RE: MP 10_0092 PART 3A EXHIBITION NORTH SYDNEY ZONE SUBSTATION

We refer to the Part 3A exhibition of the Environmental Assessment for the North Sydney Zone Substation at 3 -11 Ward St North Sydney.

This submission is made as the future owner of 136 Walker St, which lies immediately to the east of the proposed Zone Substation.

Figure 3.3.5: Elevation showing the relationship between number 136 Walker Street and the proposed substation (Source: Kann Finch Group, drawing number SD 58)

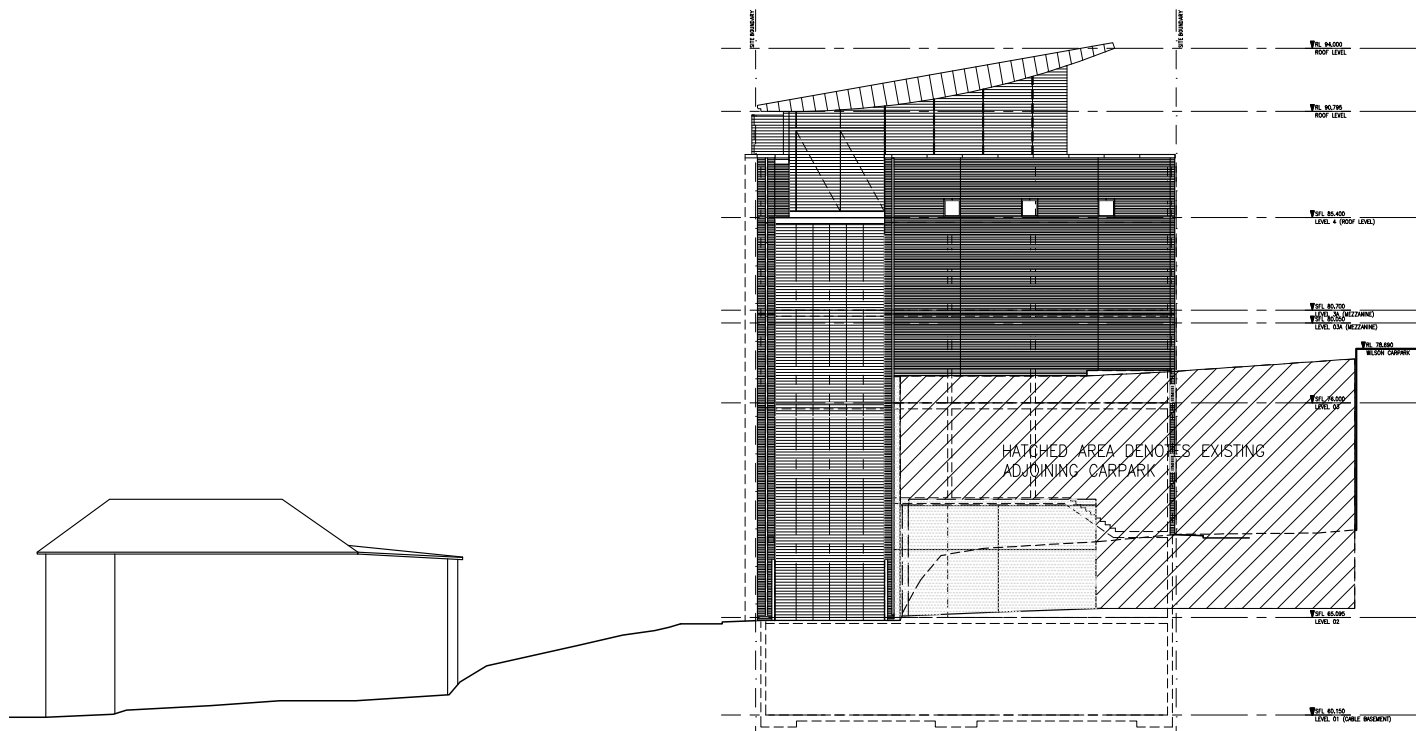
We support the position of North Sydney Council and their Design Excellence Panel in requesting that the proposed façade treatment be amended or substantially change to reduce the visual impact of the proposed substation. The level of articulation is at best providing poor visual amenity to 136 Walker St. The proposed banding offers a token relief from a 23m high blank wall with zero boundary setback.

Figure 3.1.3: Photomontage of view down Ward Street from observer location, Berry Street, post-demolition of the existing substation (Source: Kann Finch Group)

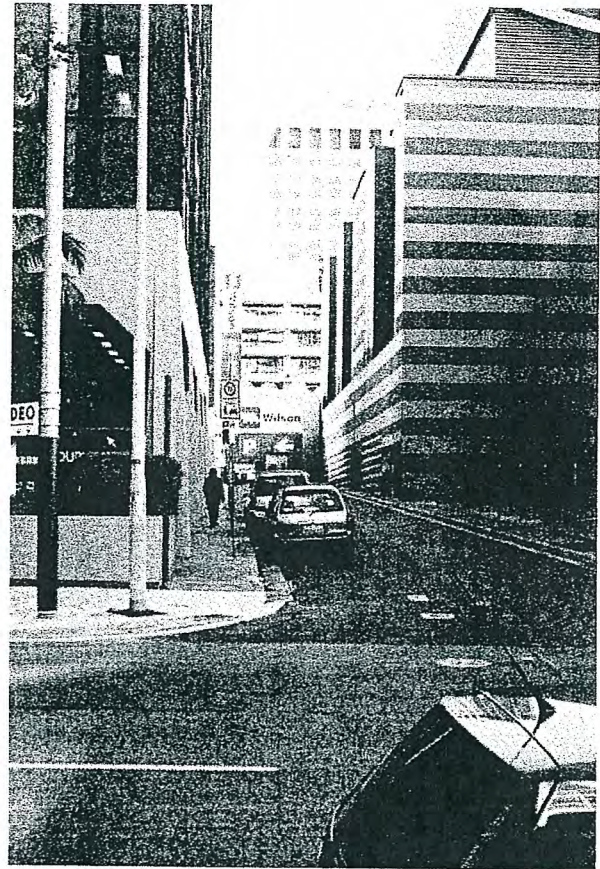
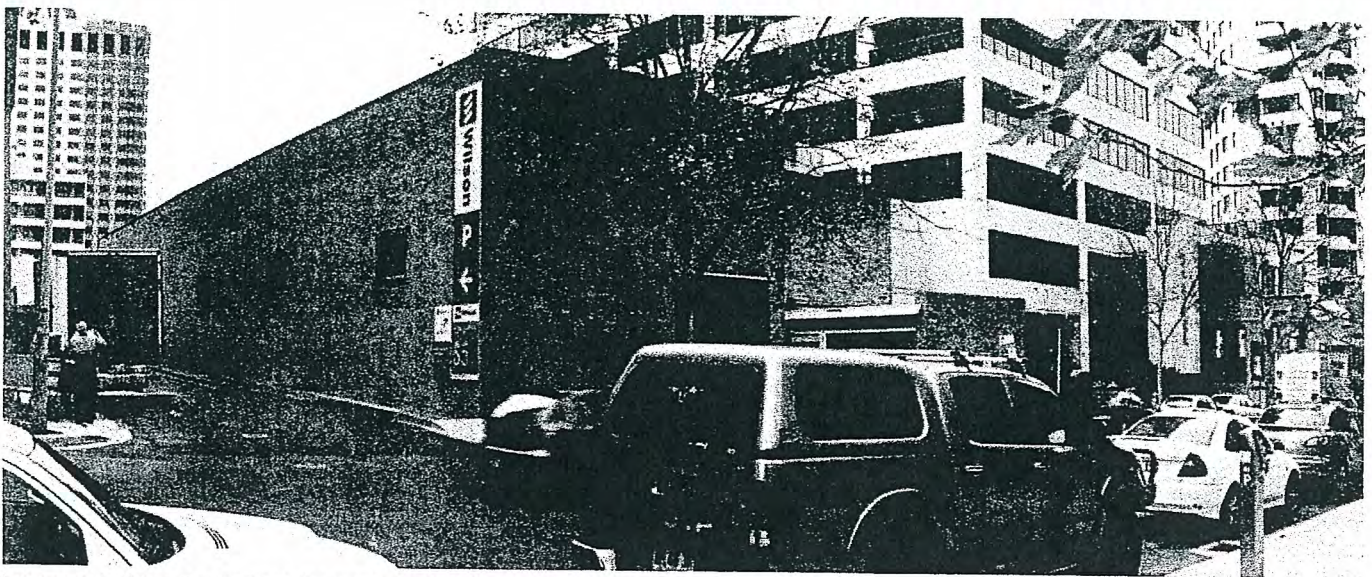
But there can be no validity in the contrary claim by Energy Australia that mitigation has been achieved by a brickwork pattern. If anything that patterning see Figure 5.1 of photo montage illustration, exaggerates the scale of the building by its uniform application to the entire building volume.
